28th May 2026

Re: Application for replacement of existing cladding, installation of new roller shutter doors, roof alterations including increase in eaves height and alterations to fenestration at 'Hangar 1'

2. Upon reviewing the approved plans, we have identified that the approved elevations and roof plan for Hangar 1 (ref: **F/9/23/PL**) do not fully reflect the intended design.
3. We are therefore submitting this application for

HANGAR 1, PROPOSED SOUTH ELEVATION (1:200)

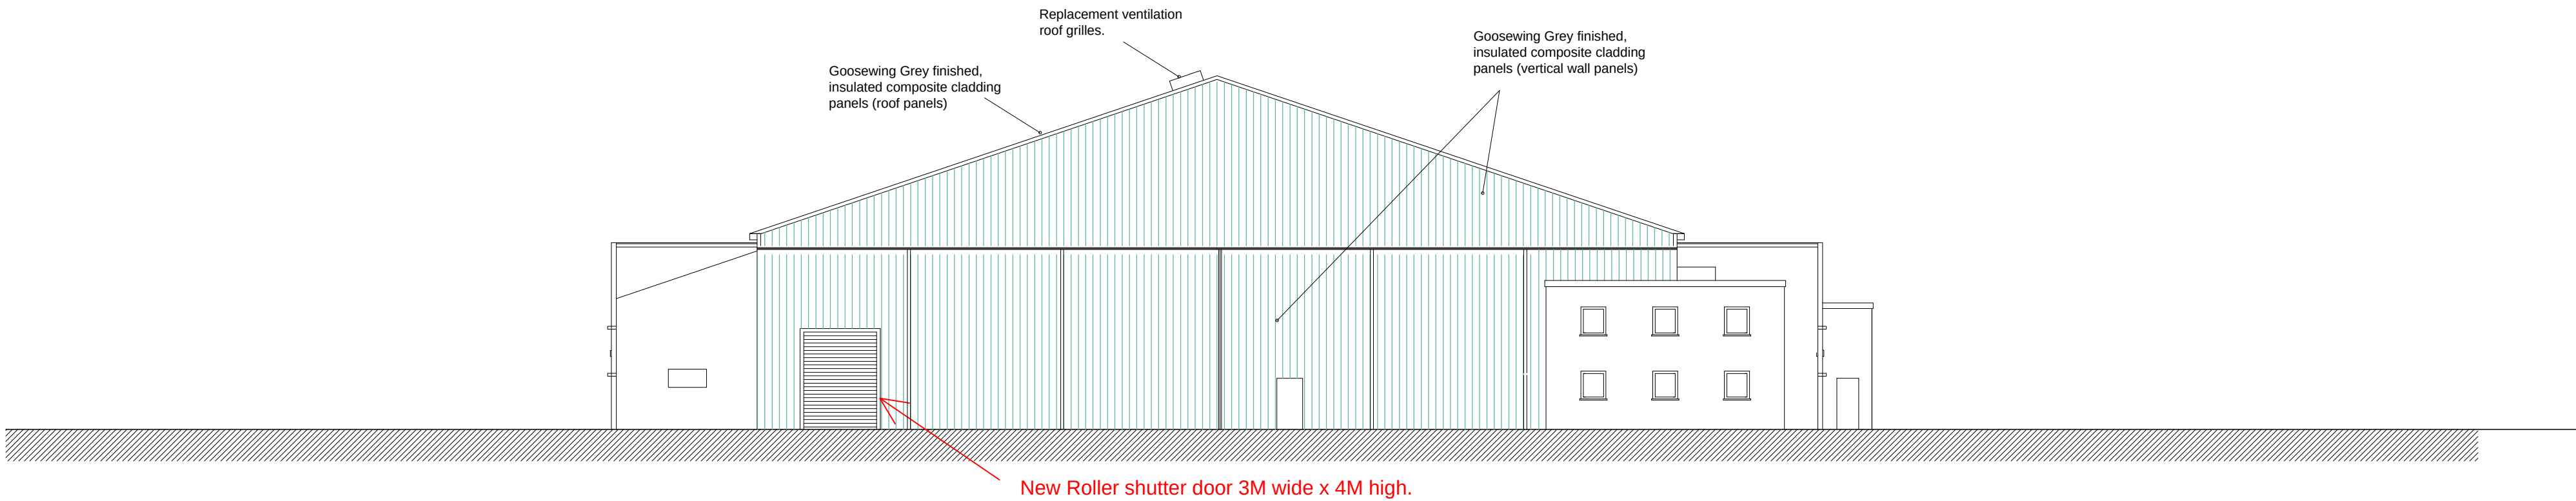
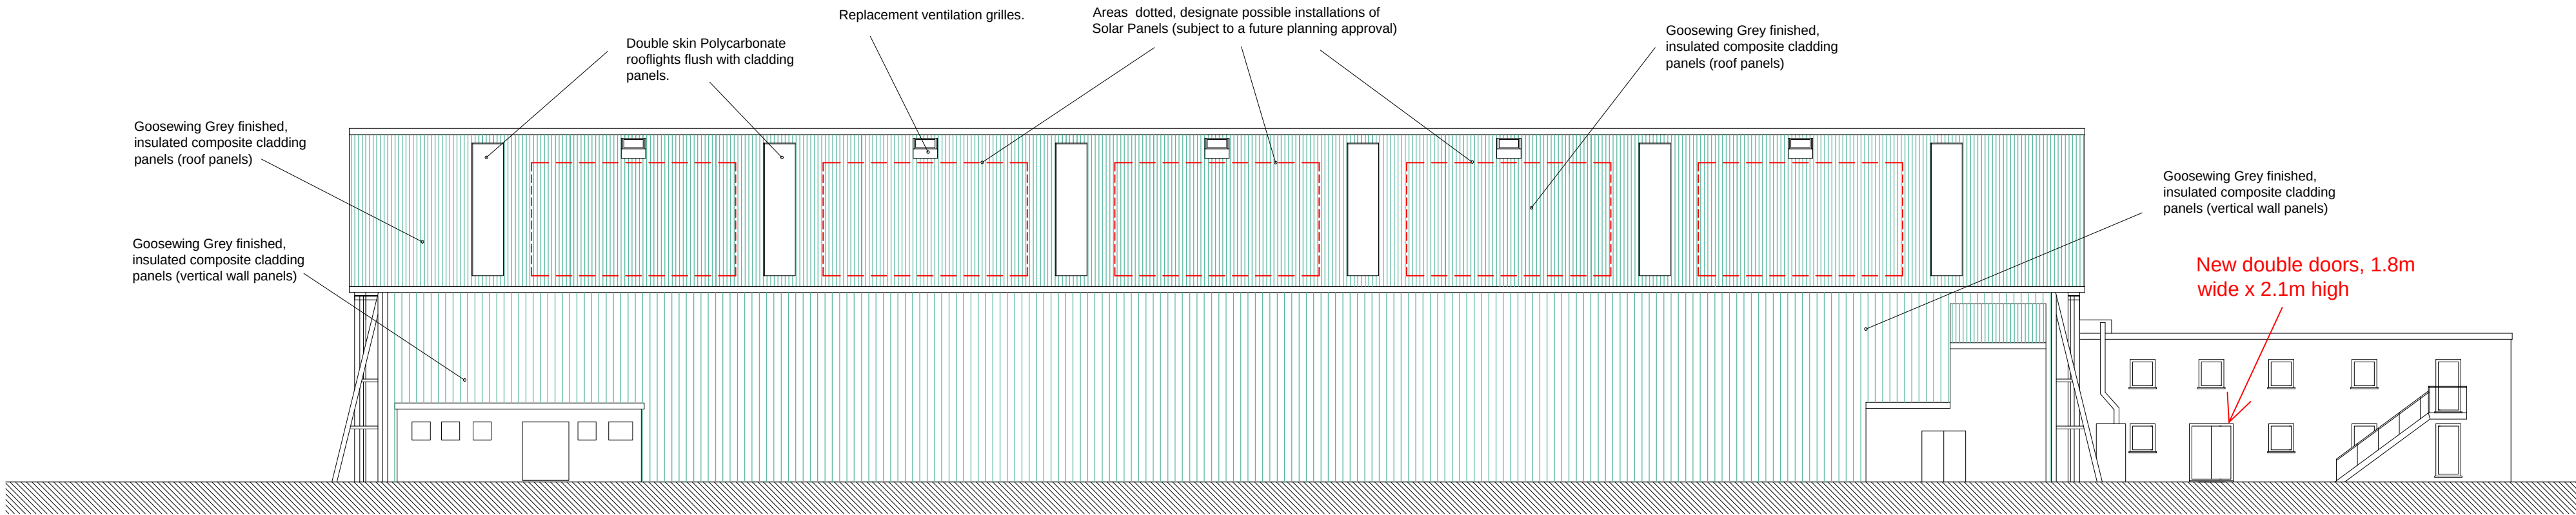
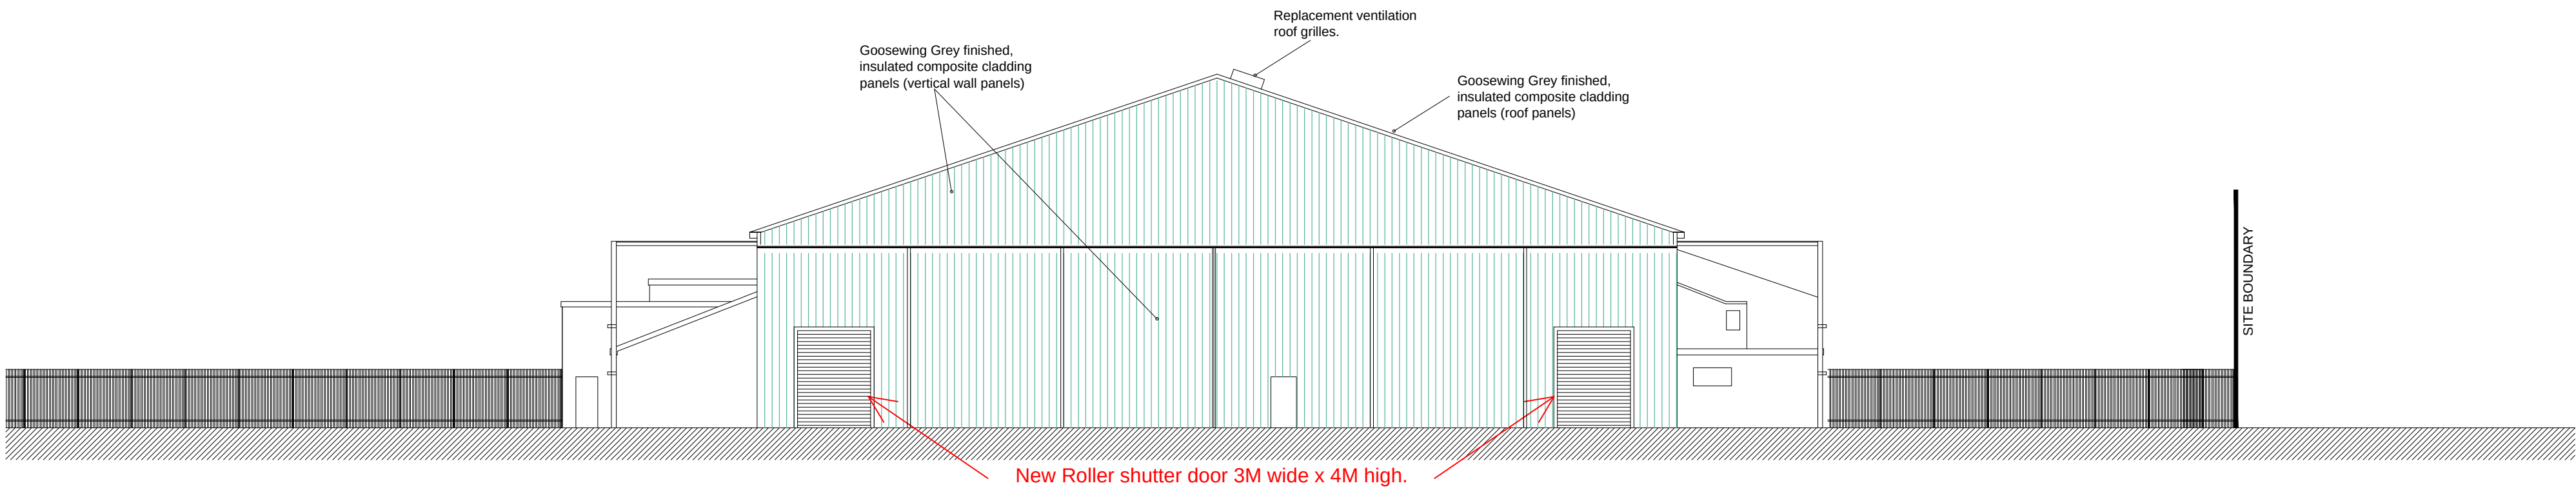
- Hangar 1 Elevations, Ref. DG/EN/FOR/WDL/2234 (issue date 05/05/2026)
- 6. The proposed changes for this application from the approved Hangar 1 application (ref: **F/9/23/PL**) relate to changes to the eaves height and associated alterations to the elevations and roof form, bringing Hangar 1 into closer alignment with the approved design for Hangar 2.

- 7. The eaves height of Hangar 1 would be increased from 8.66m to 12.19m, with the ridge height remaining unchanged.
- 8. This application mirrors the approved changes at Hangar 2 whilst following the approved Hangar 1 permission, ensuring a consistent design approach across the site.

- 9. The revised eaves height, elevations, and roof form are considered to result in a more coherent appearance, allowing the buildings to integrate more effectively within the wider site context. The design approach is consistent with that approved under application ref. **F/1/26/PL**.

DRAWN IE	CHECKED --	DATE 06/03/2025	SCALE 1-500 @A3
DRG.No. DG/EN/FOR/WDL/2233

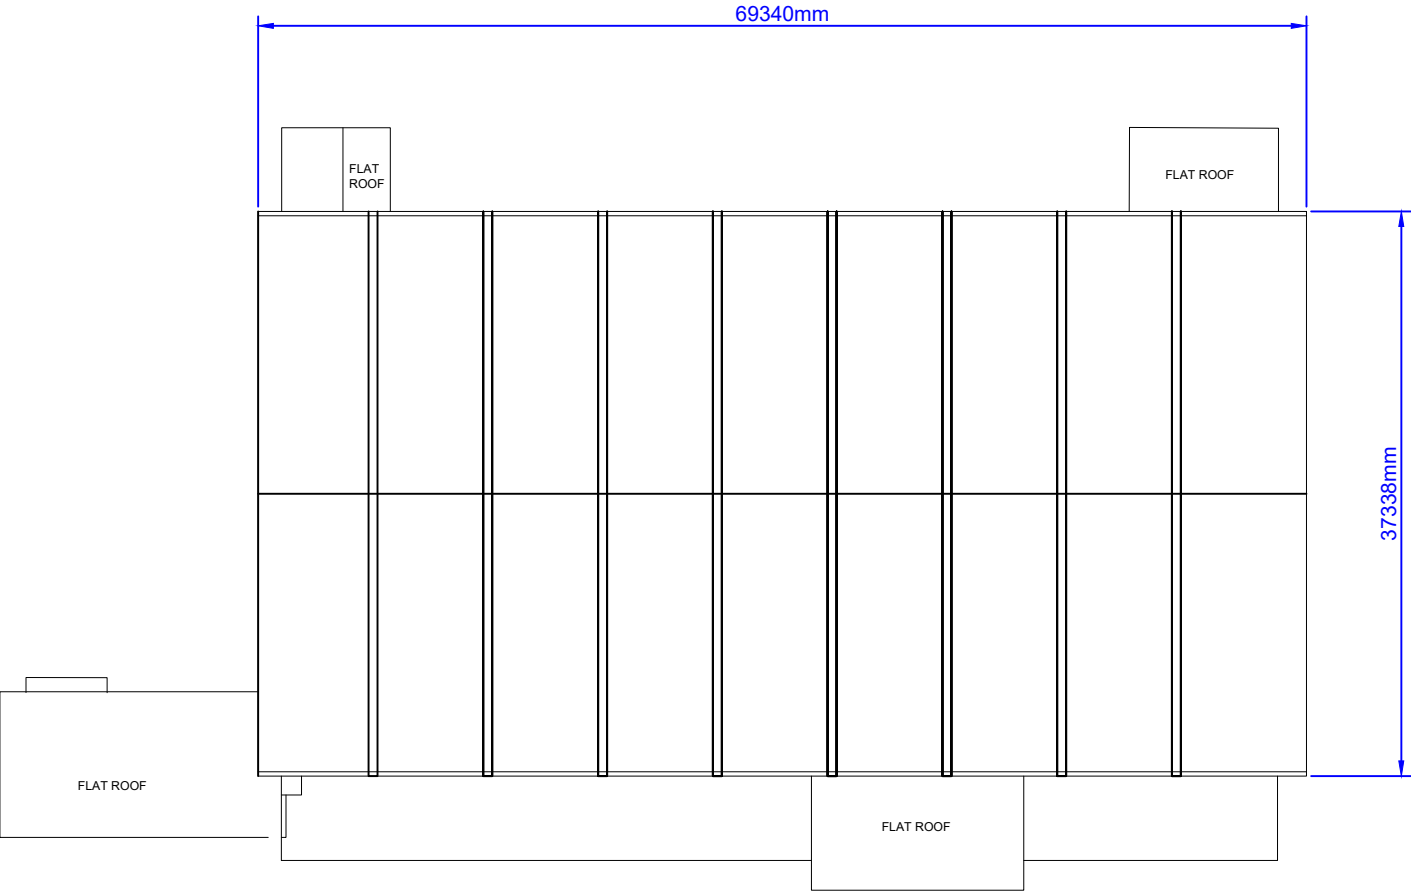
4. This application allows us to facilitate the previously approved Hangar 1 improvement works, whilst aligning more closely with the recently approved works at Hangar 2 (ref: **F/1/26/PL**), located on the same site, approximately 60m to the east.
5. The only plans in this application that differ from the plans approved in application ref: **F/9/23/PL** are:
 - Proposed Roof Plan, Dwg. No. 20342-02-PR-002 Rev.01
 - Proposed Elevations, Dwg. No. 20342-05-PR-000 Rev.01
5. These are to be replaced with the following revised drawings:
 - Hangar 1 Roof Plan, Ref. DG/EN/FOR/WDL/2233 (issue date 05/03/2026)
